## PARKS AND COMMUNITY SERVICES DEPARTMENT

March 13, 2024

**Subject: Grandview Reserve Phase II PUD Development Plan and Preliminary Plan, 2<sup>nd</sup> Submittal (PUDSP-24-006)**

LANDSCAPE  
 PRELIMINARY LANDSCAPE PLAN (OVERALL)

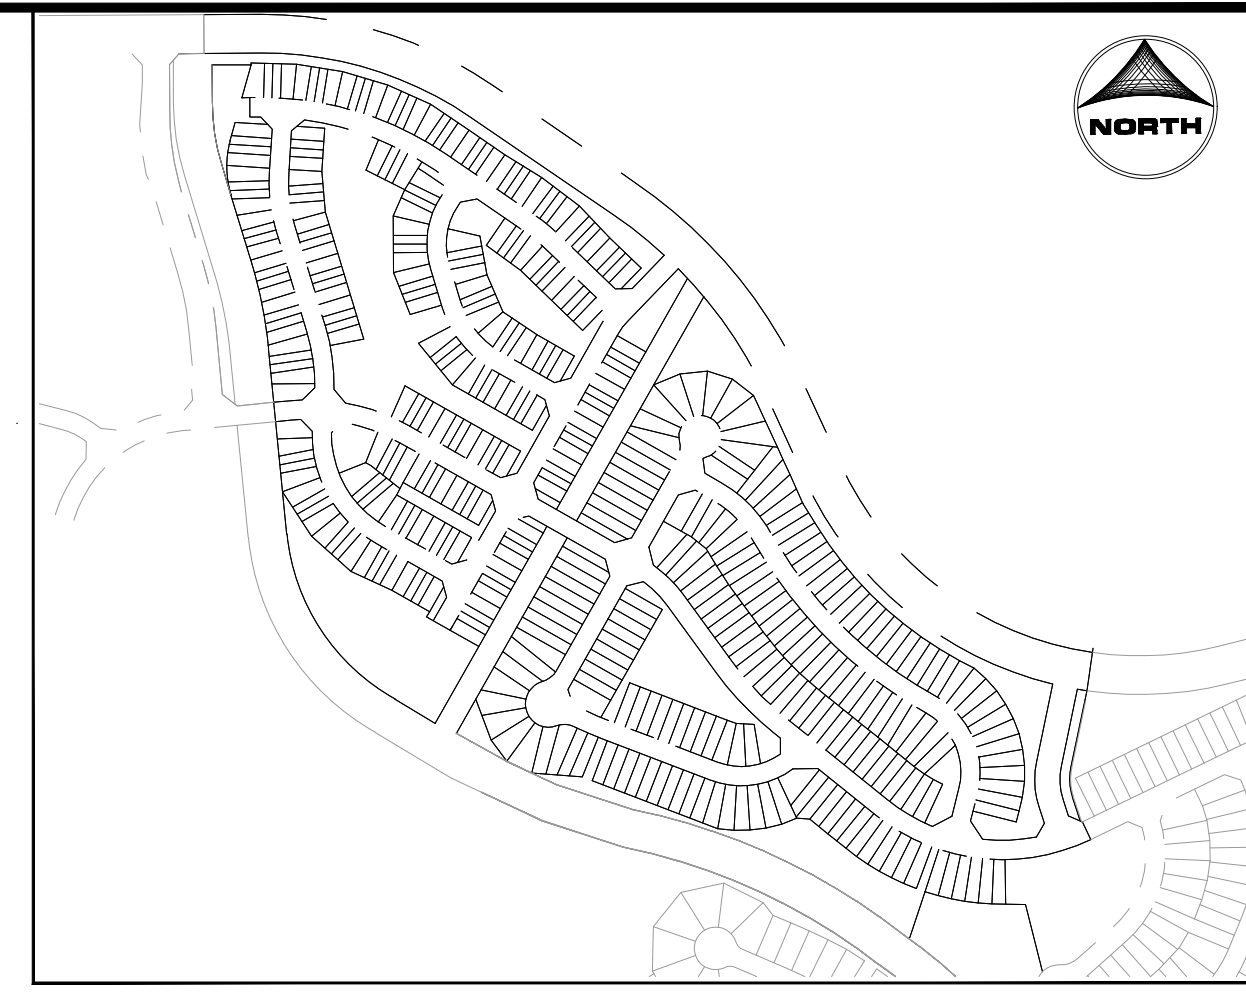
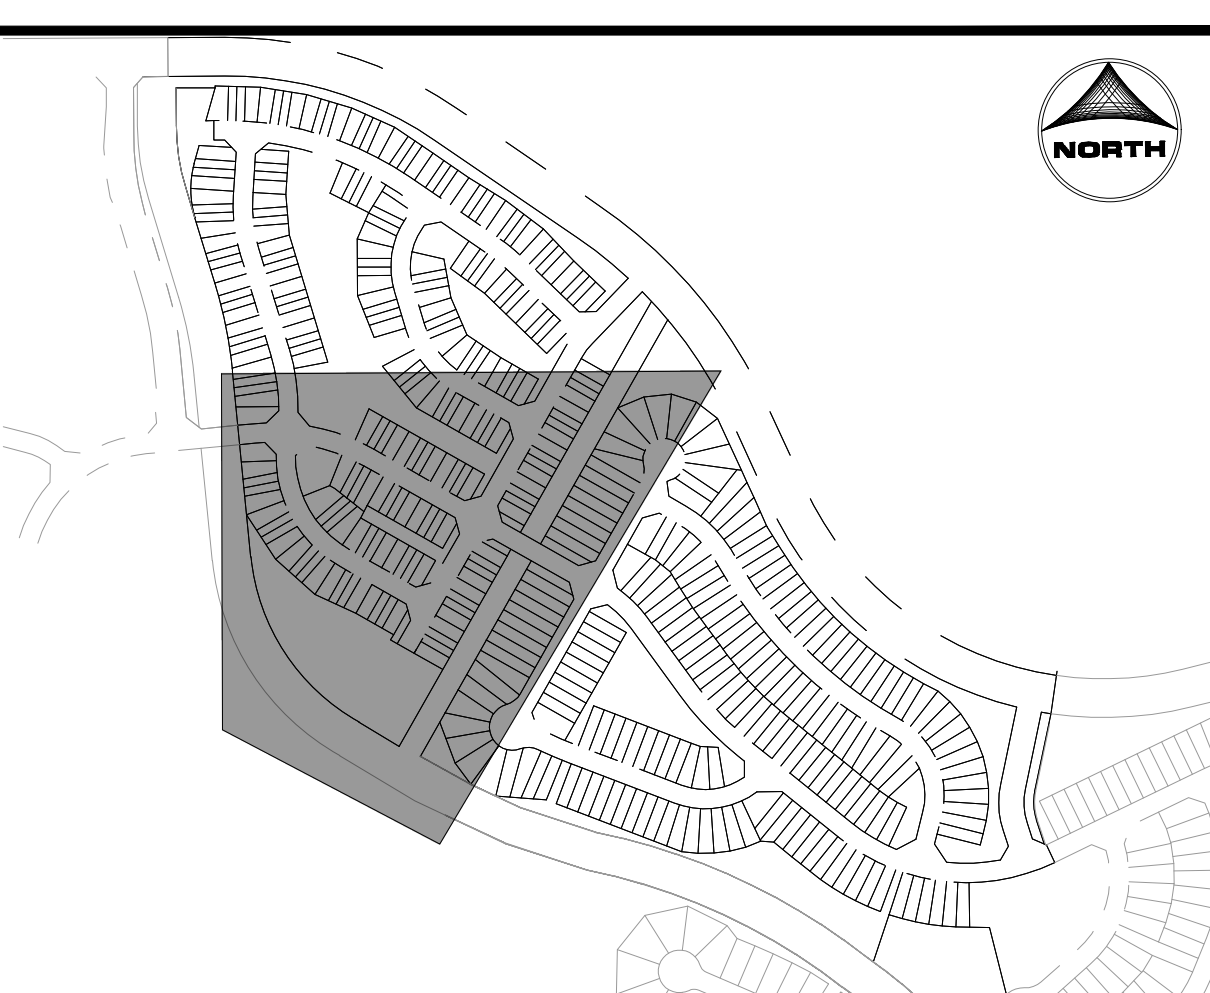
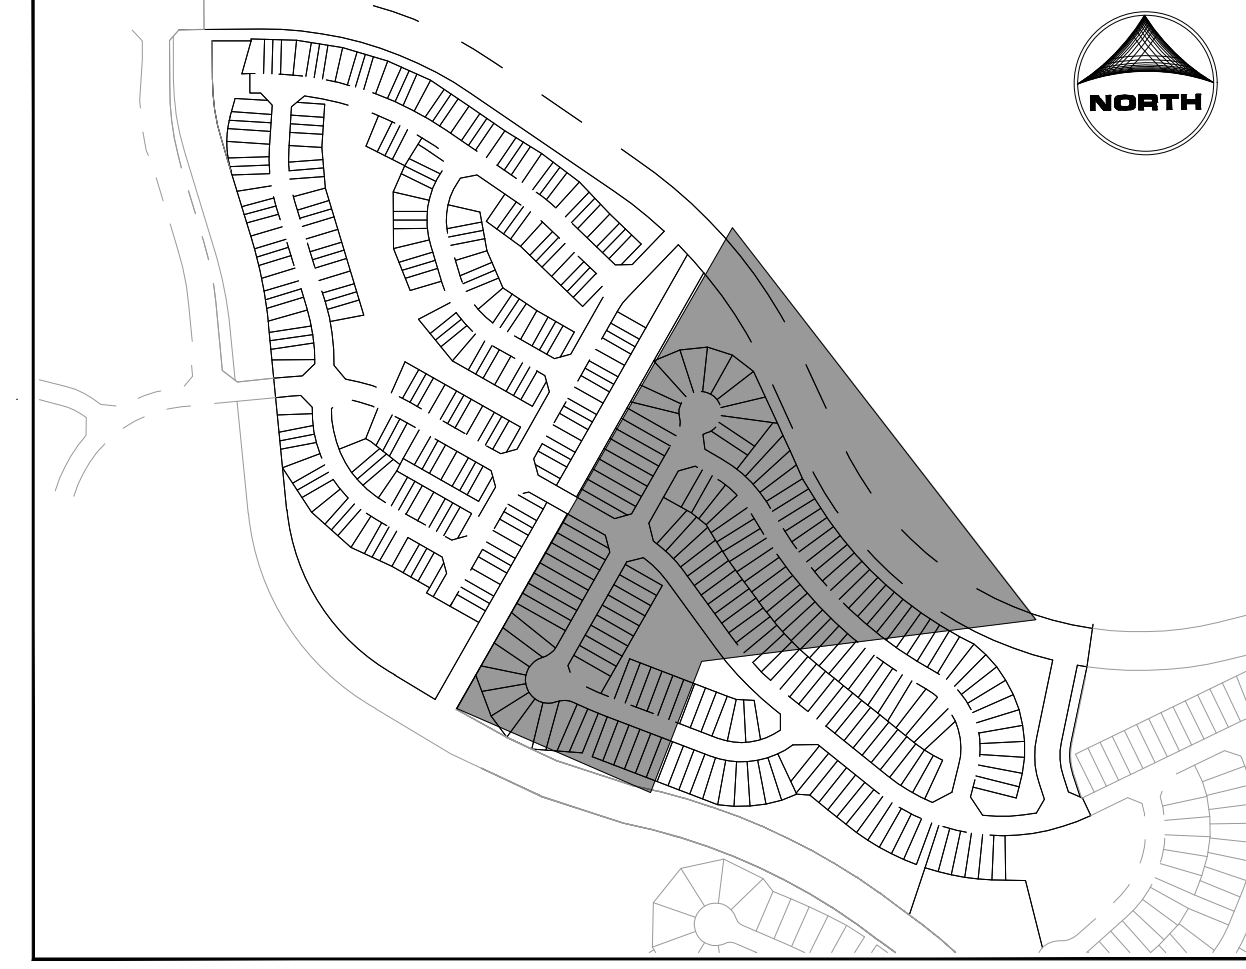
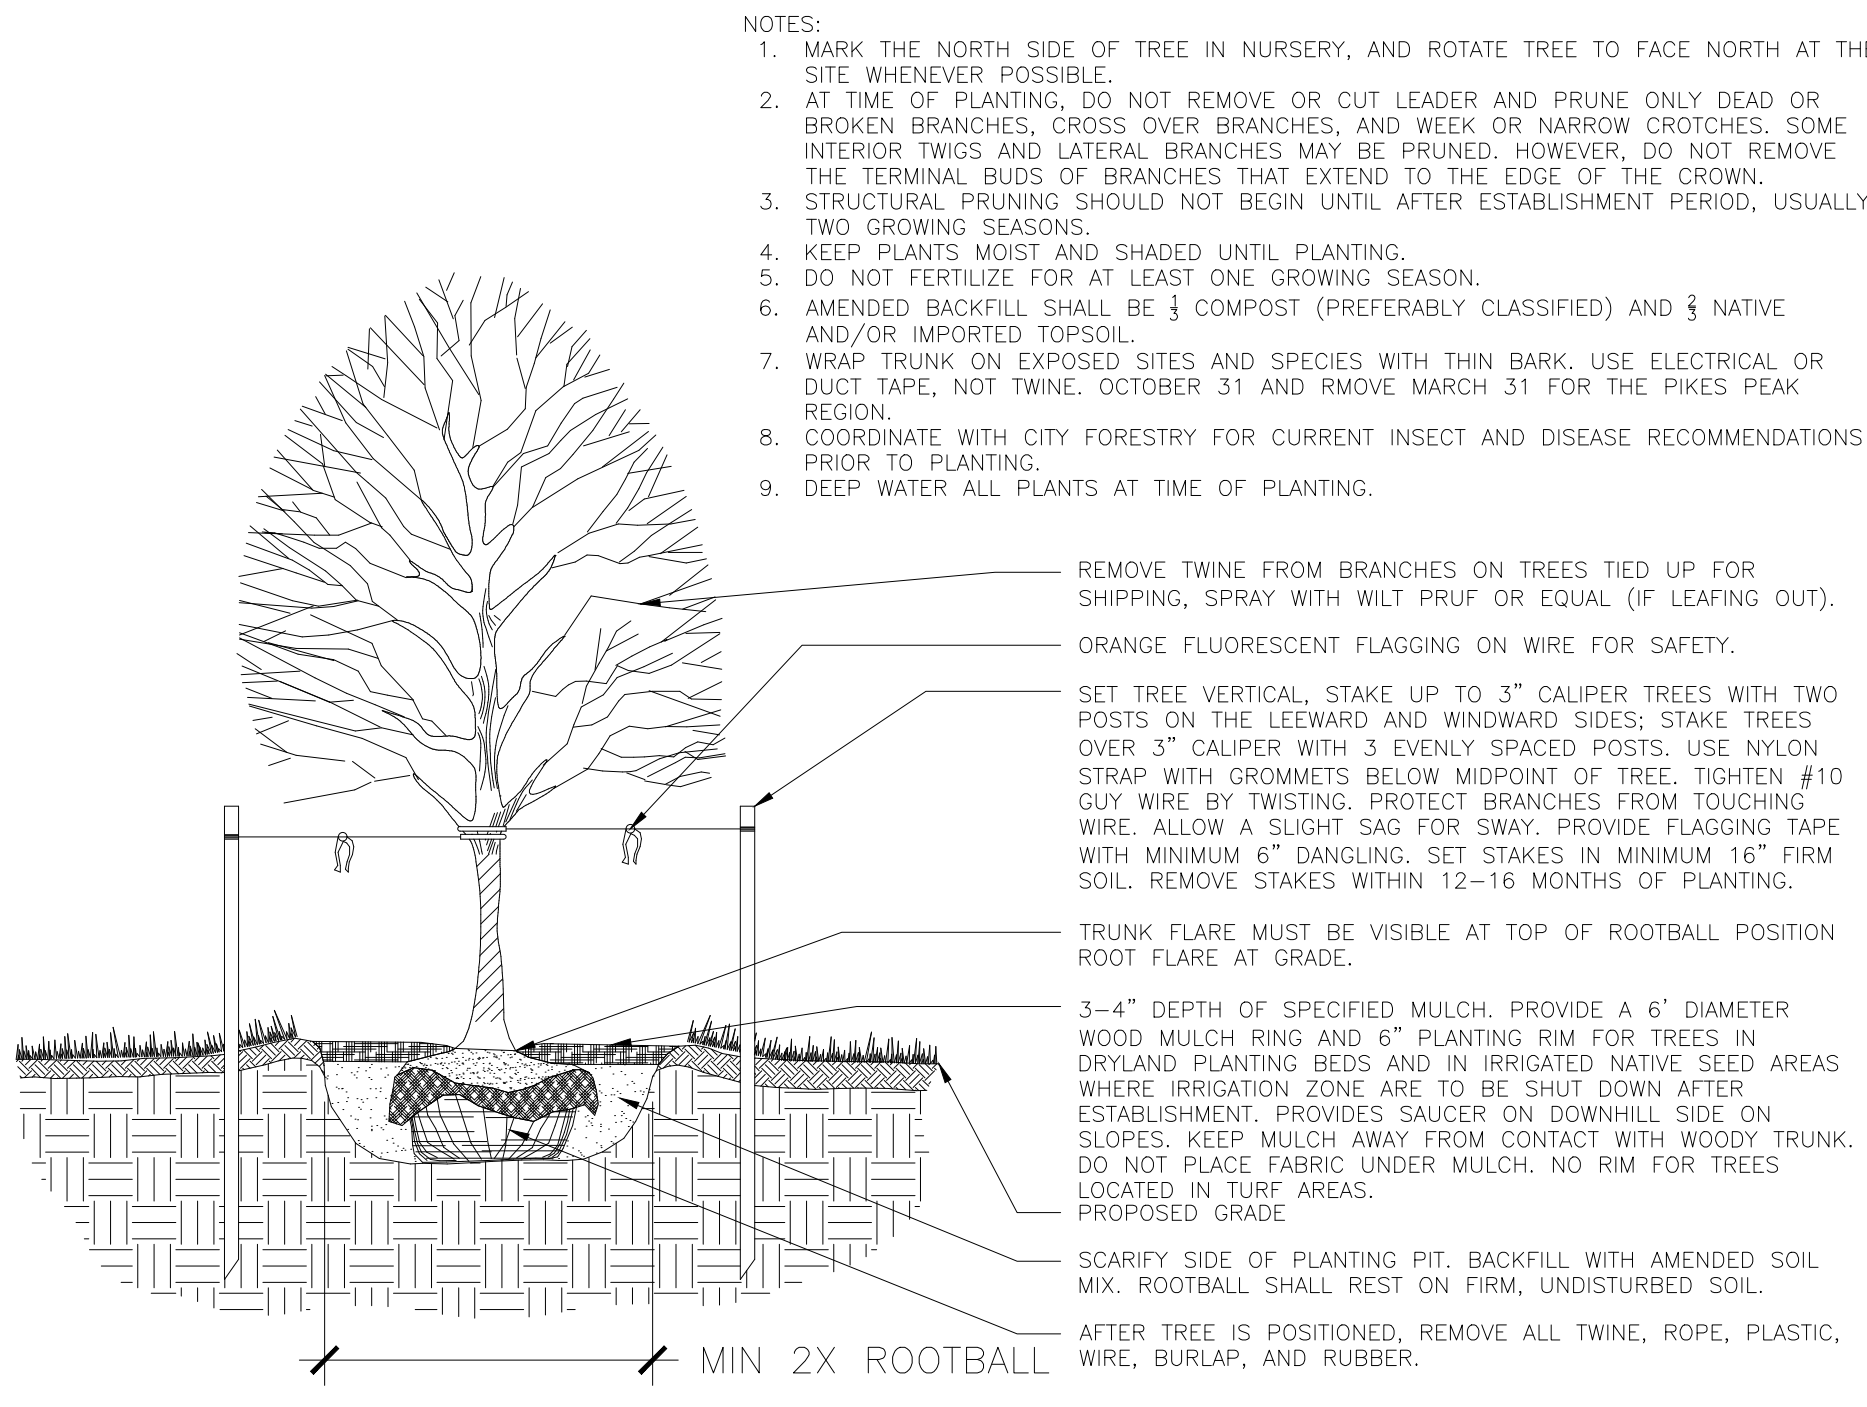
EPC staff is encouraged by the applicant's willingness to provide extensive recreational amenities for its residents and citizens of El Paso County through the development of an expansive and connected park, trail, and open space system. Staff recommends that the applicant submit detailed site plans for the proposed neighborhood park and include multi-generational recreational amenities such as a playground, multi-use turf field, and/or seating and picnic areas. The submitted Landscape Plans are rather limited and only show half of the proposed park area.

The Park Advisory Board recommends that the Planning Commission and the Board of County Commissioners include the following conditions when considering and/or approving the Grandview Reserve Phase II PUD Development Plan and Preliminary Plan: (1) provide detailed site plans for the proposed neighborhood park; (2) fees in lieu of land dedication for regional park purposes in the amount of \$211,090
